Application no: H14-0189-15

Description: Proposed replacement dwelling

Amendment: Amend from double to triple garage & from pan roof
tiles to black (dwg. nos. AB-02C and AB-03)

ACKNOWLEDGEMENT OF AMENDMENT

PROPOSED SITE PLAN 1:200

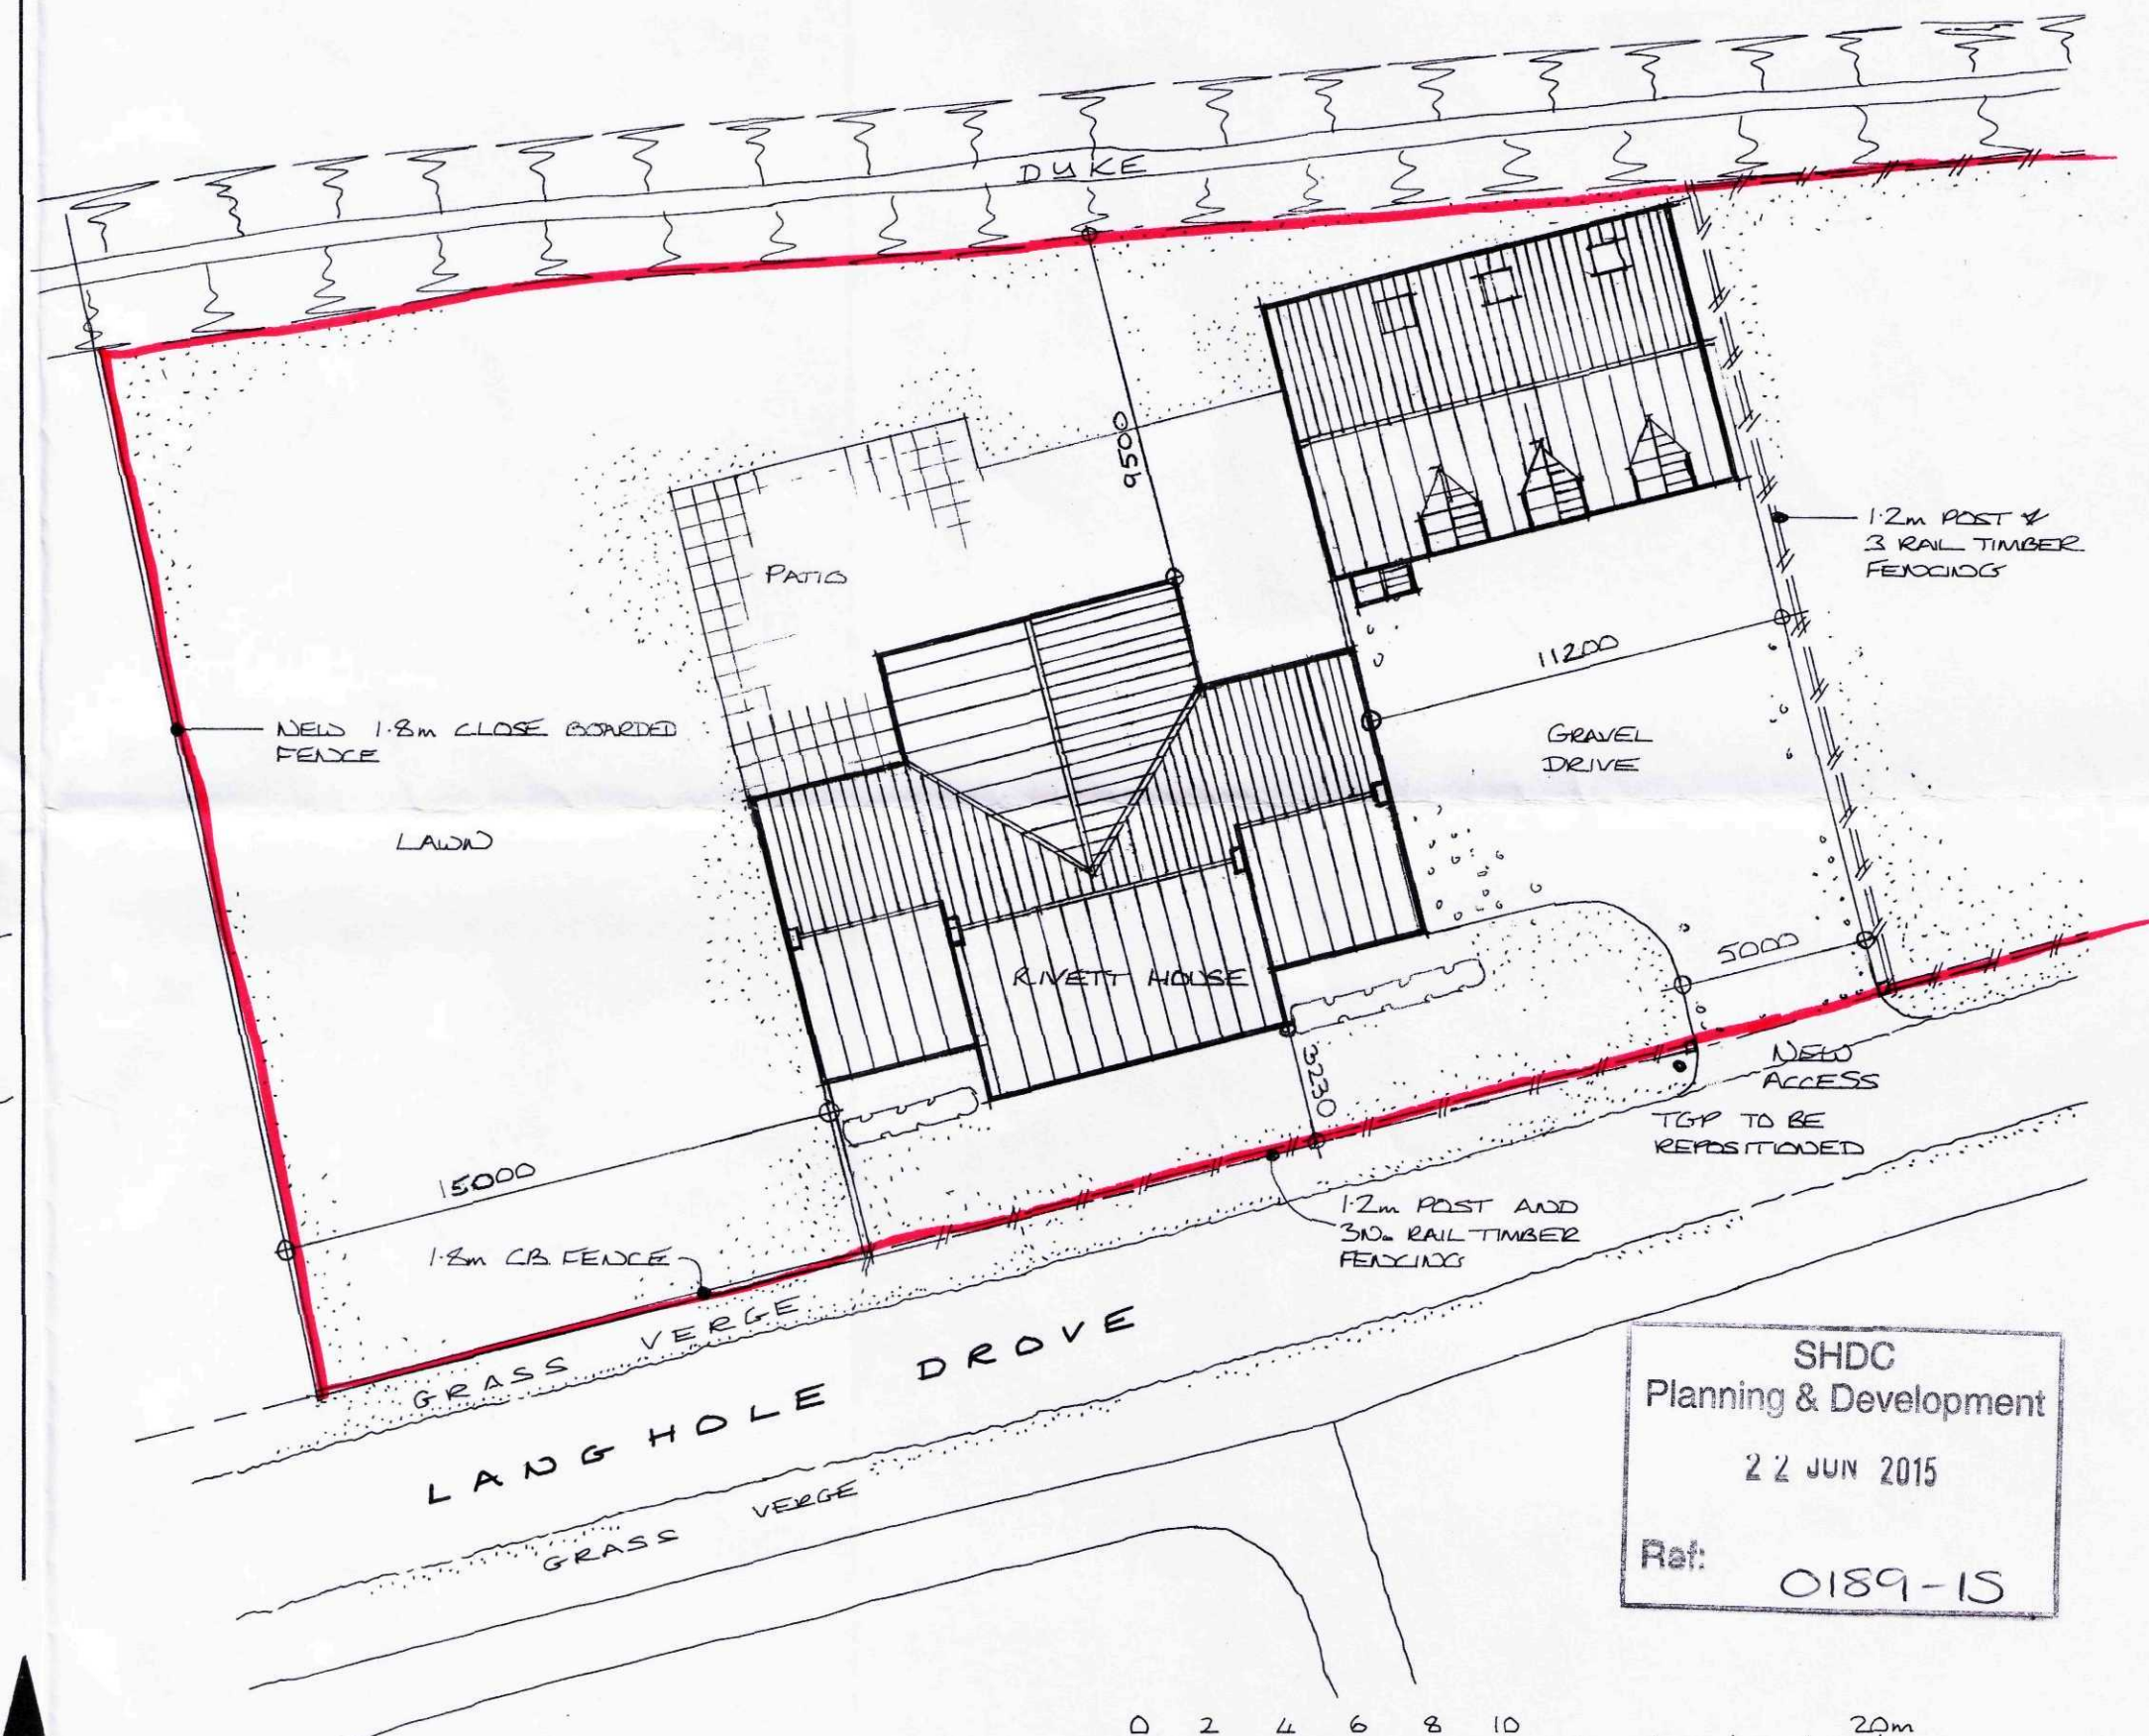
Following our discussion about the Garage at the above property I enclose the original and 3 copies of the following drawings for inclusion/substitution into my application and your approval.

Existing and Proposed Site Plans AB/02RevC.

Rev	Date	Copyright reserved	Do not scale	All dimensions to be checked on site
Project	ALTERATIONS AND EXTENSION TO RIVETT HOUSE, LANGHOLE DRIVE, PINCHBECK			
Drawing	PROPOSED GARAGE FLOOR PLANS AND ELEVATIONS			
Date	18/06/15	Scale	1:100, 1:50	Job No
				Dm No. AB-03
				Rev

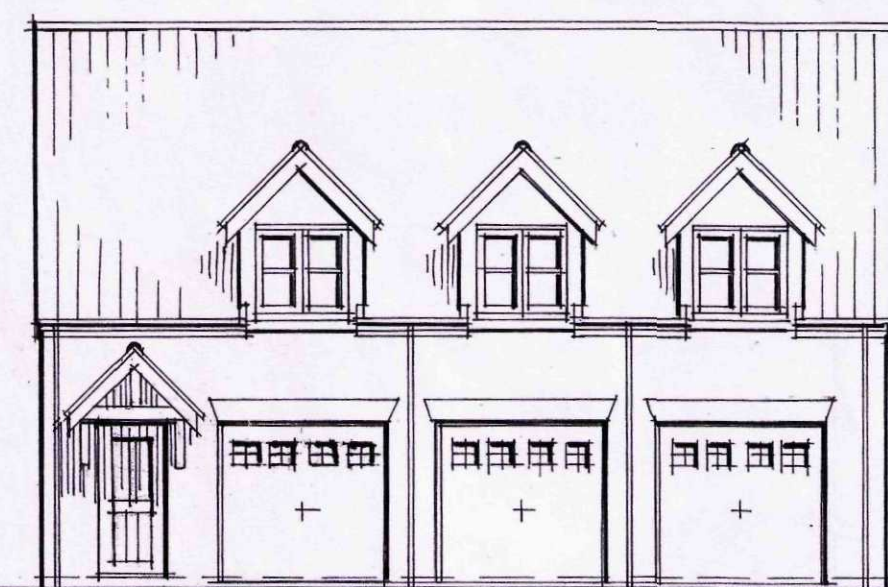
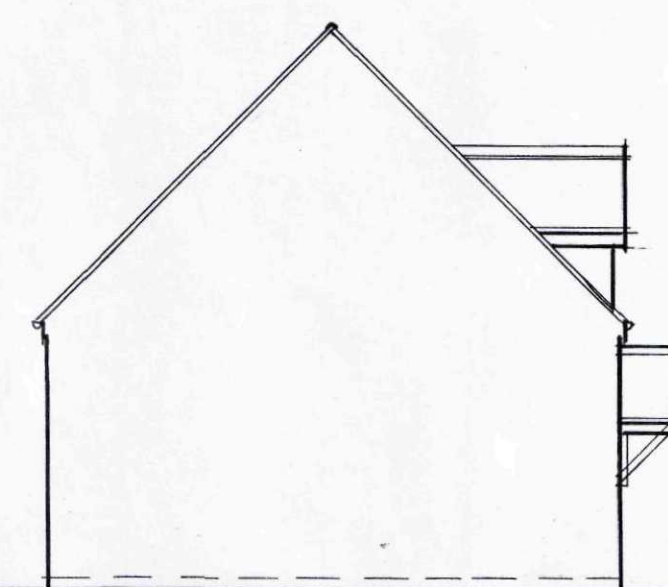
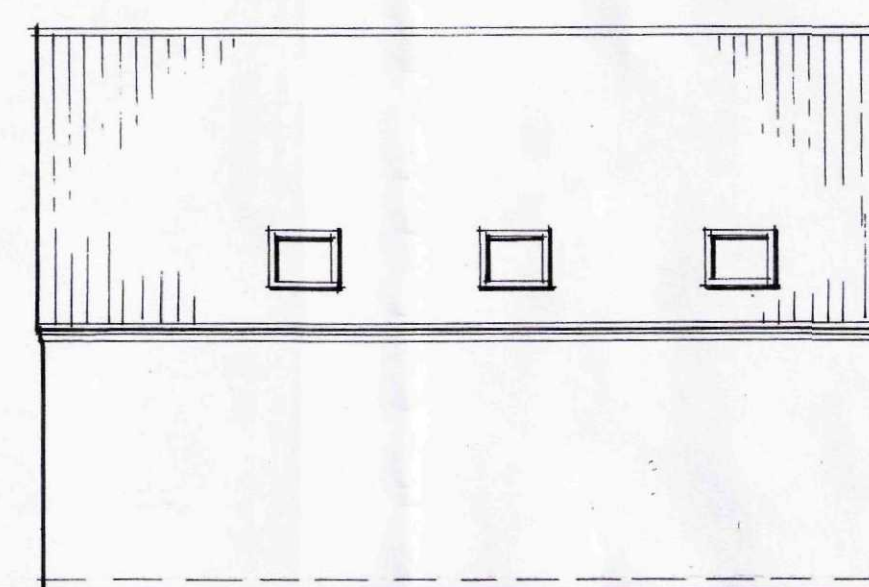
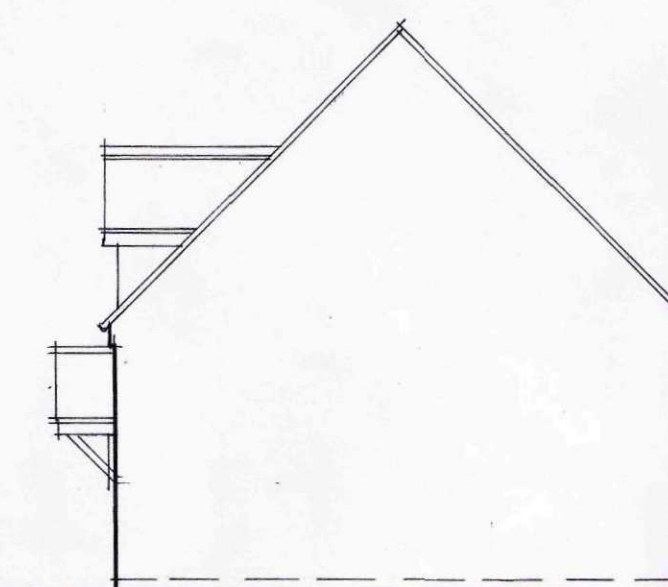
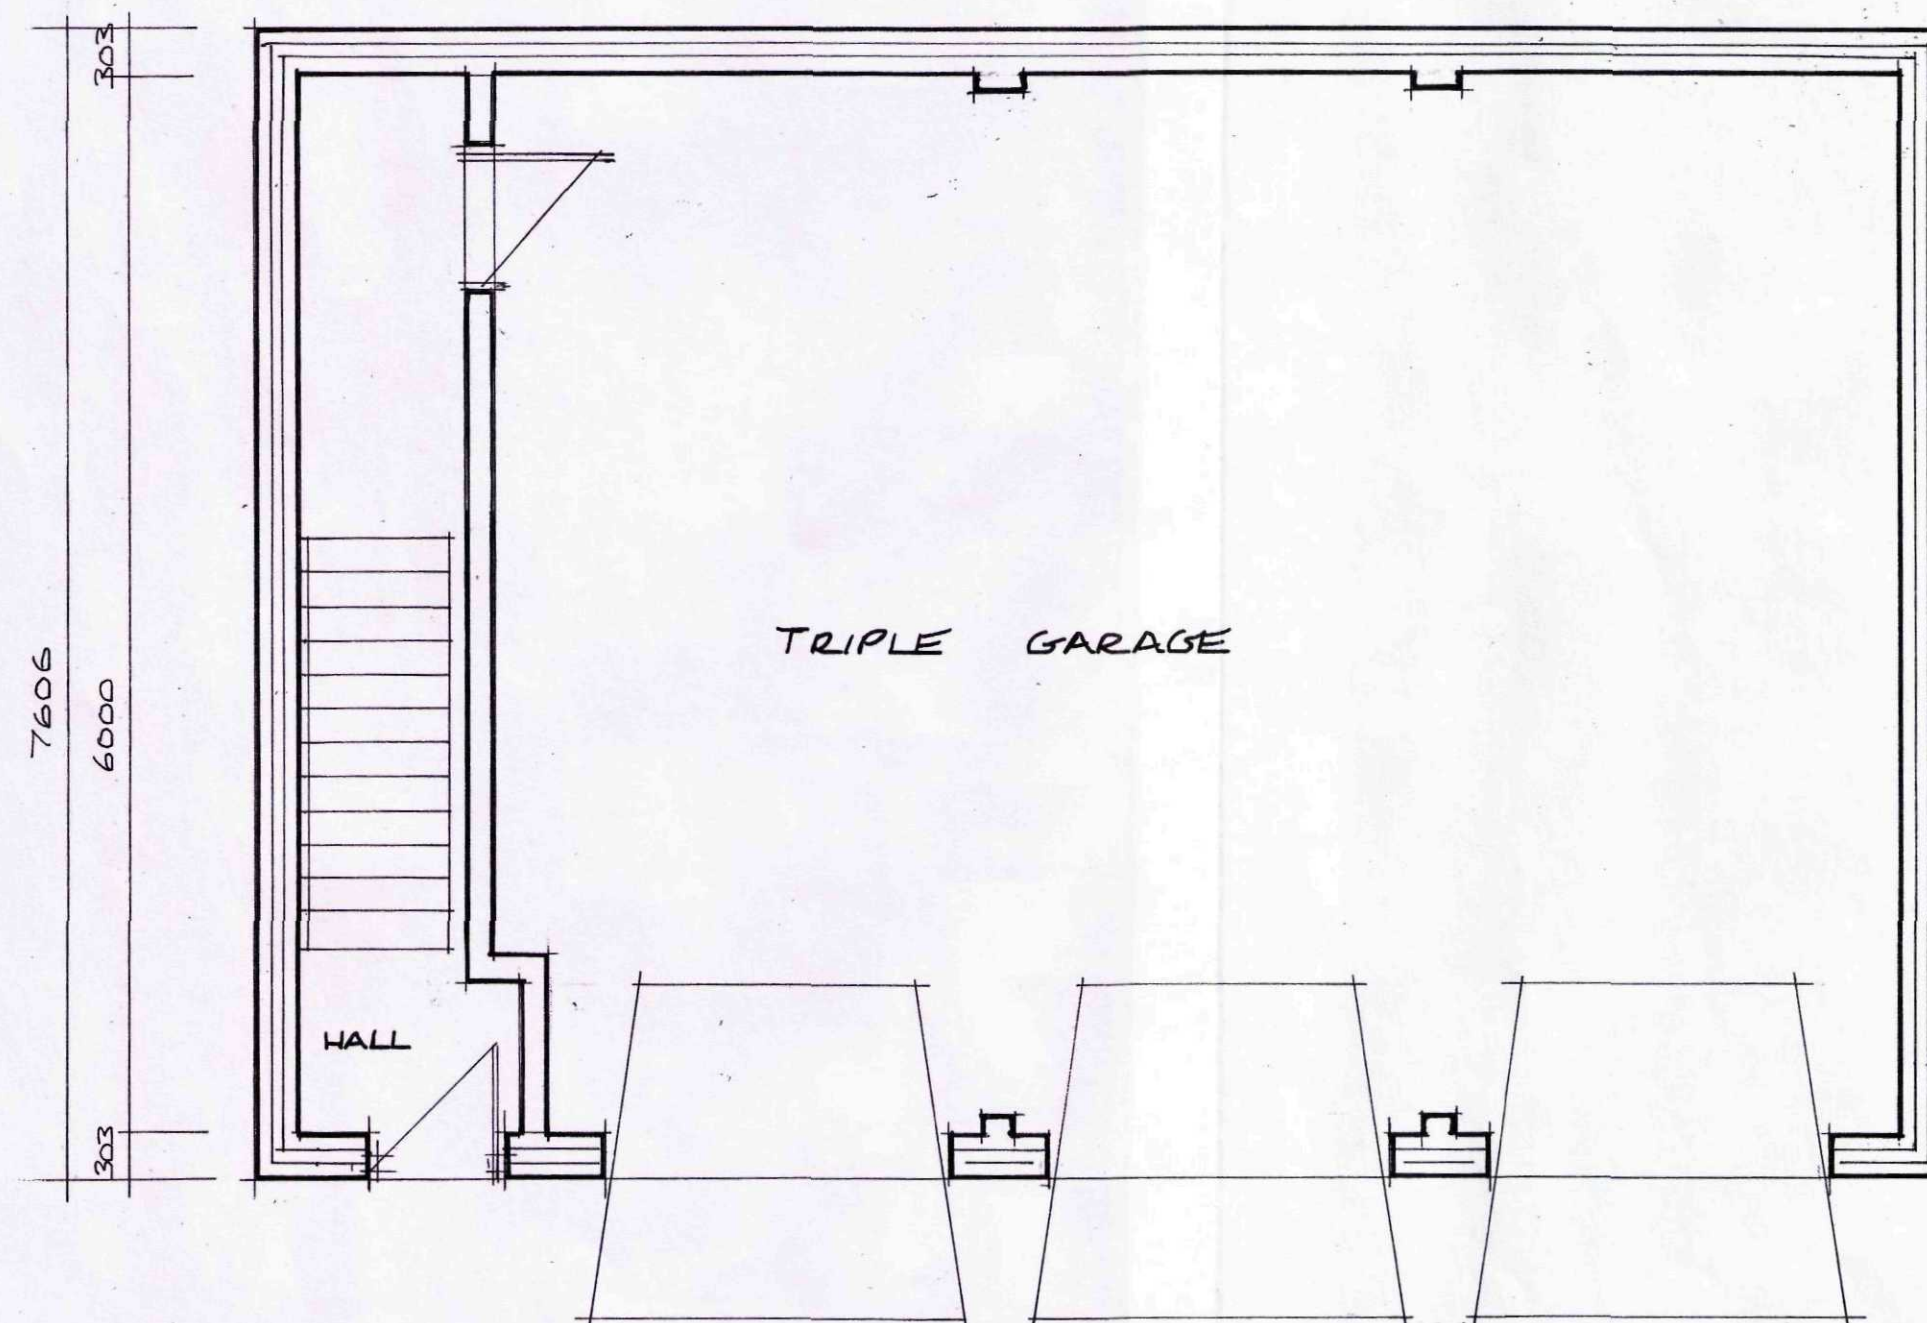
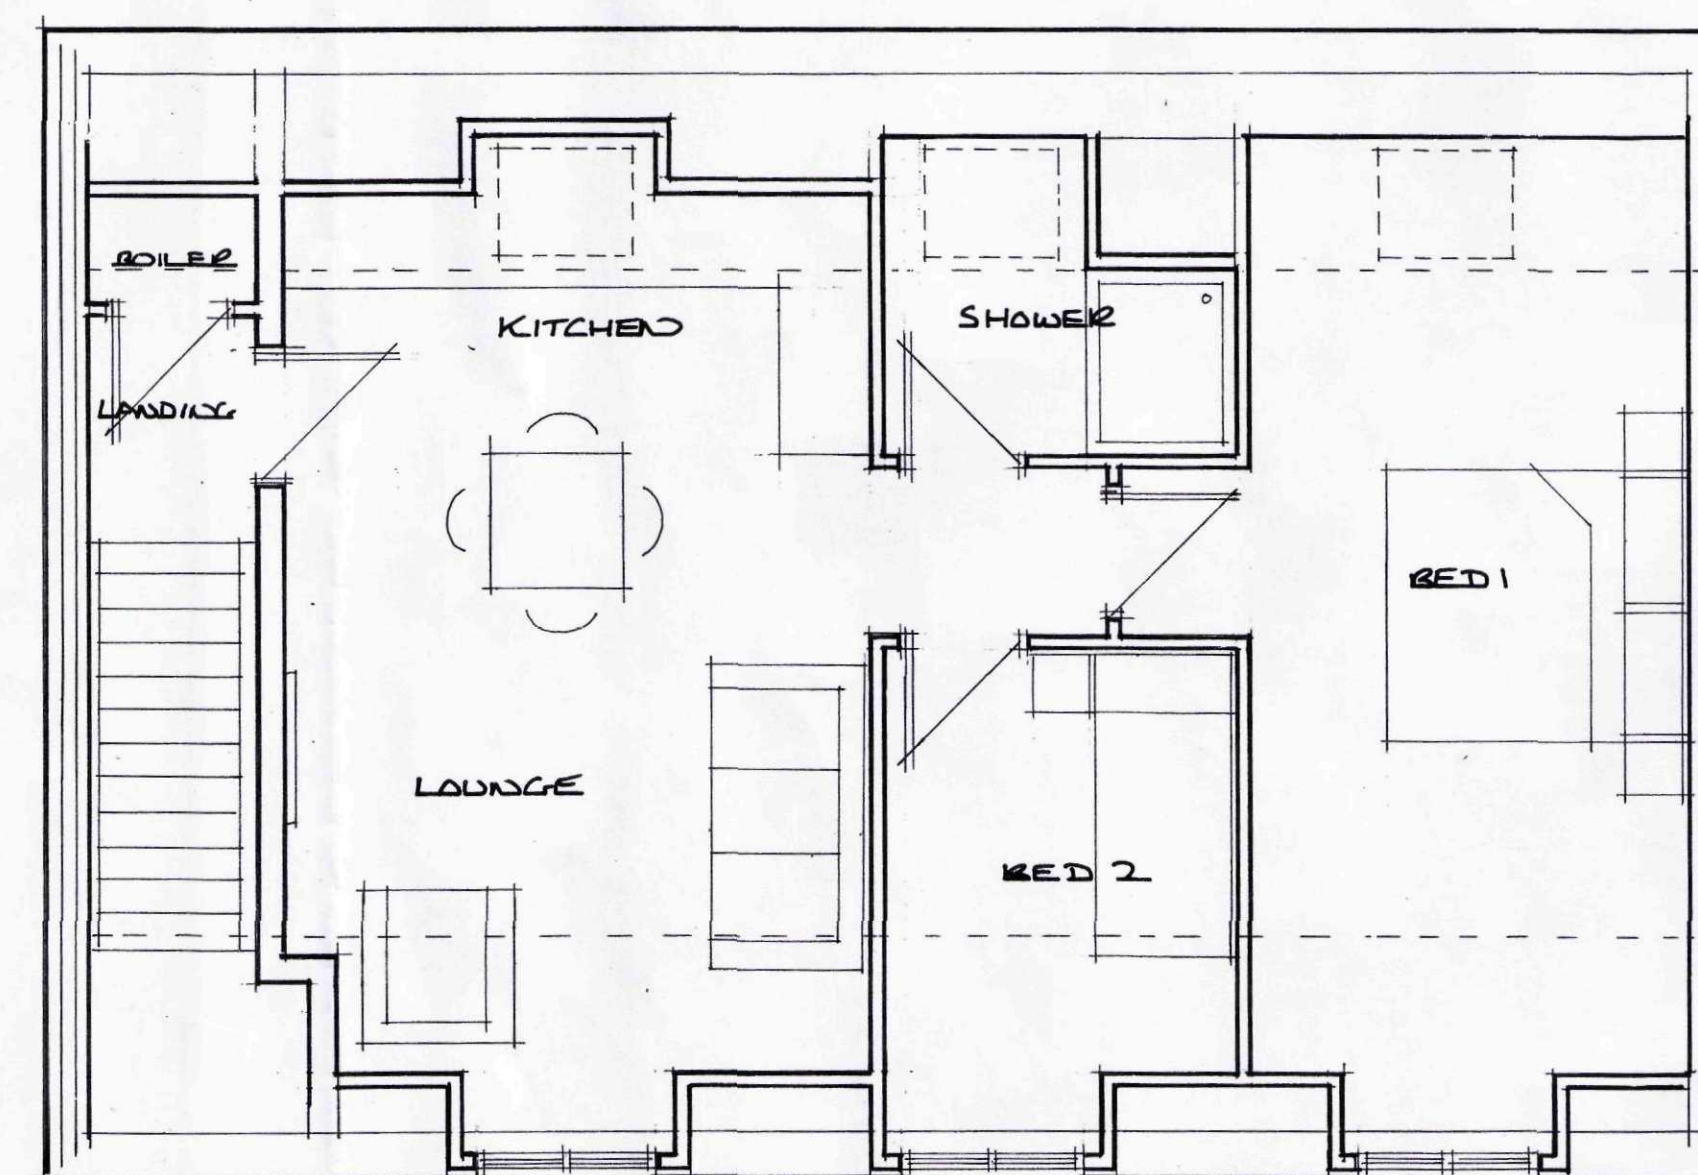
Double Detached Garage AB/03
